Item No. **Report of the Head of Development Management and Building Control**

Address: 2 ROCHESTER ROAD NORTHWOOD

Development: Erection of a single storey extension to rear (Retrospective application)

LBH Ref Nos: 1383/APP/2023/2294

Proposed Plans, Section and Elevations

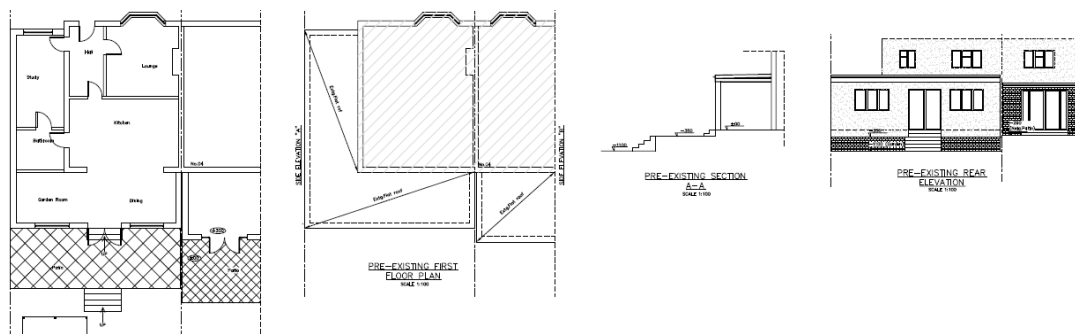
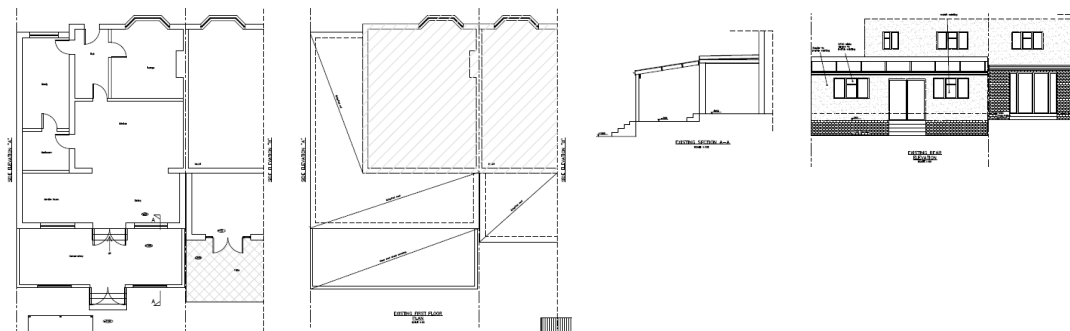
of 3m, a length of 9m and features a sloping roof measuring a maximum height of 2.9m. The resulting single storey rear extension measures a depth of 6m, a width of 8.9m and features a part flat roof and part sloping roof. Policy DMHD 1 states that single storey rear extensions should not exceed 3.6m in depth. Further, supporting paragraph A1.7 of the Local Plan (2020) states that the addition of conservatories or other extensions to buildings that have already been extended will not be permitted.

It is acknowledged there are a number of properties in the surrounding area that benefit from rear additions. However, the proposed depth of the rear extension of 6m, is not common within the surrounding area. Moreover, the mismatch of materials (and their construction quality which appears incomplete), and the mismatched roof design and junction, exacerbate the harm of the 6m deep extension. The development would represent a poor standard of design to the detriment of the character and appearance of the dwelling, as well as that of the surrounding area.

The proposed extension by reason of its overall depth and scale, design, materials and appearance, in conjunction with the existing rear extension, would fail to appear subordinate to the original property or respect its architectural composition and appearance, giving rise to a visually harmful, dominant and poorly designed form of development which would be detrimental to the character and appearance of the site and surrounding area. The proposal is therefore contrary to Policy BE1 of the Hillingdon Local Plan: Part One - Strategic Policies (November 2012), policies DMHB11 and DMHD1 of the Hillingdon Local Plan - Part One (2020), policy D3 of the London Plan (2021) and Chapter 12 of the National Planning Policy Framework (2021).
